G-4638

**Subject: WET SEASON GRADING LIMITATION  
– SEASONAL DEVELOPMENT WAIVER  
PROPOSED NEW RESIDENCE  
4276 EAST MERCER WAY  
MERCER ISLAND, WASHINGTON**

**Permit No.: 2103-055**

DRAWING NO:
C1.0

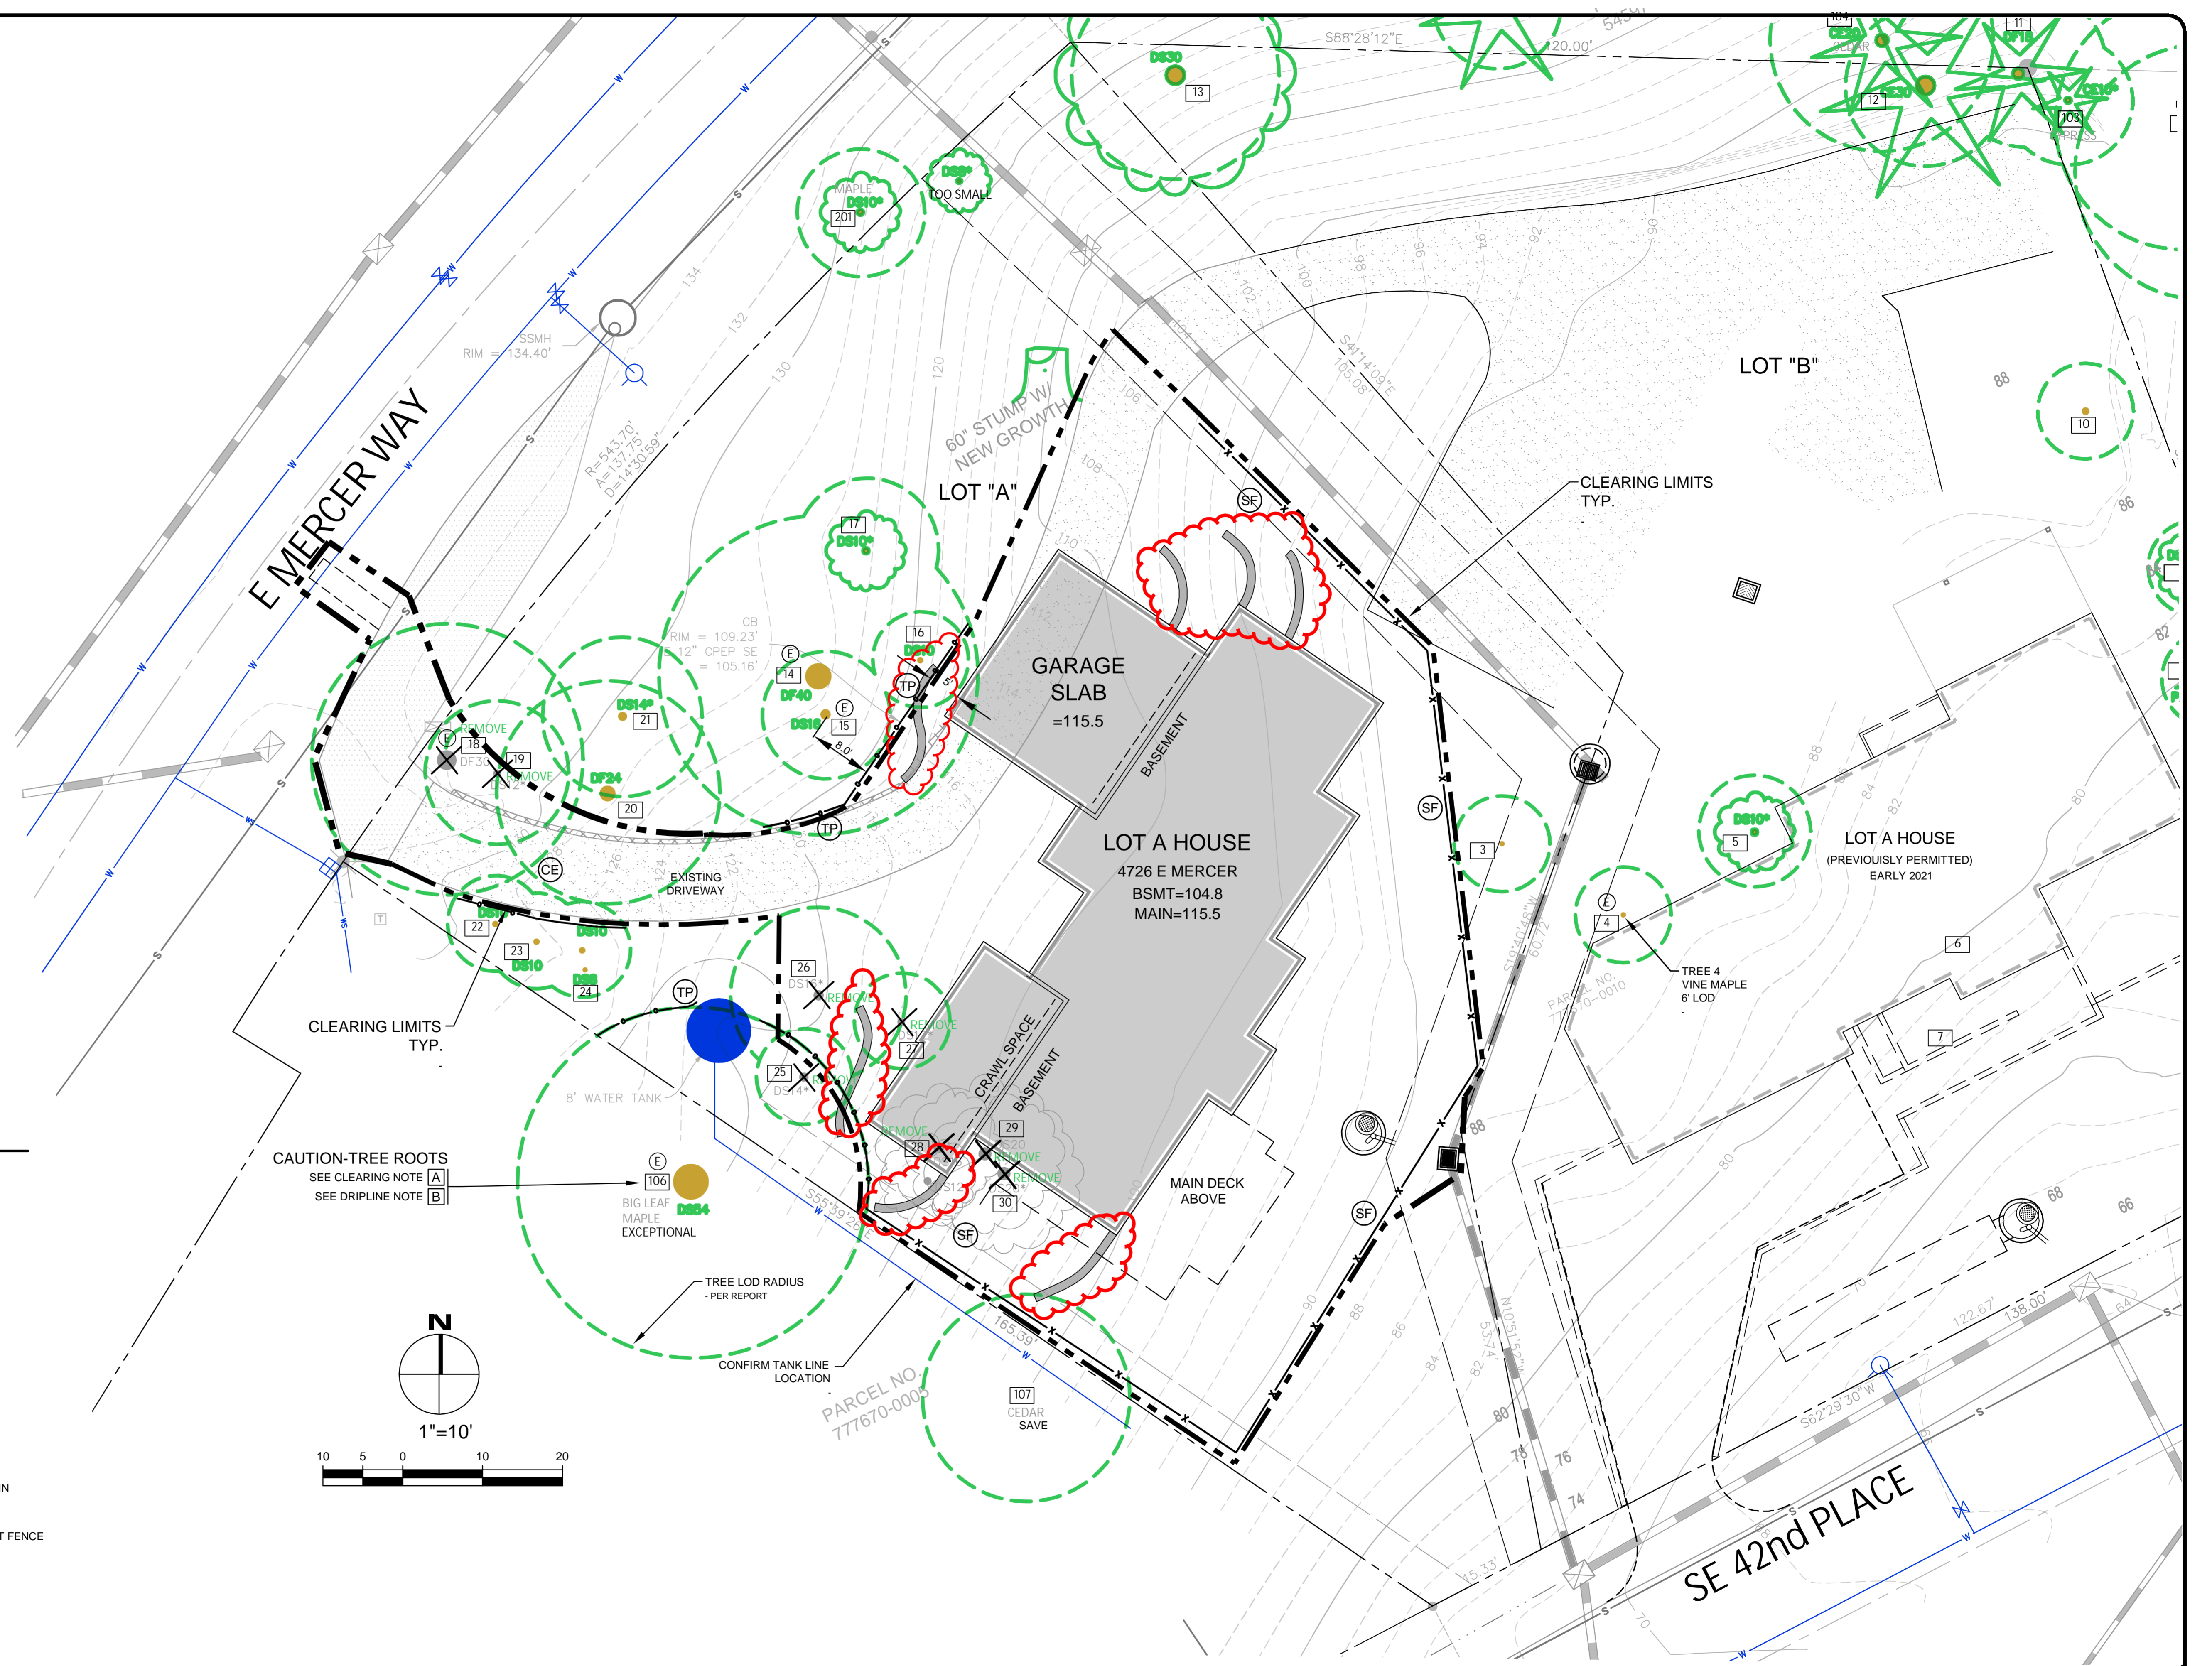
1. A filter fabric fence is not located at the south and west sides of the work area, per the Erosion Control plan (Sheet C1.0);
2. The steep excavation slopes at the lower portion of the building pad are not currently covered with plastic sheeting;
3. There are some areas having gentle to moderate slopes at the access road (lower section) and at the south disturbed area which remain unprotected from wet weather impacts.

1. A filter fabric fence should be installed at all areas shown on the Erosion Control plan, namely the south and west;
2. Plastic sheeting is recommended to be draped and anchored over the currently un-covered steep excavation slopes at the lower portion of the building pad;
3. Straw or plastic sheeting is recommended to be placed at the disturbed soil areas at the south side of the building pad and at the lower portion of the access road area. Straw is preferred for these gentle to moderate inclination areas to facilitate access.
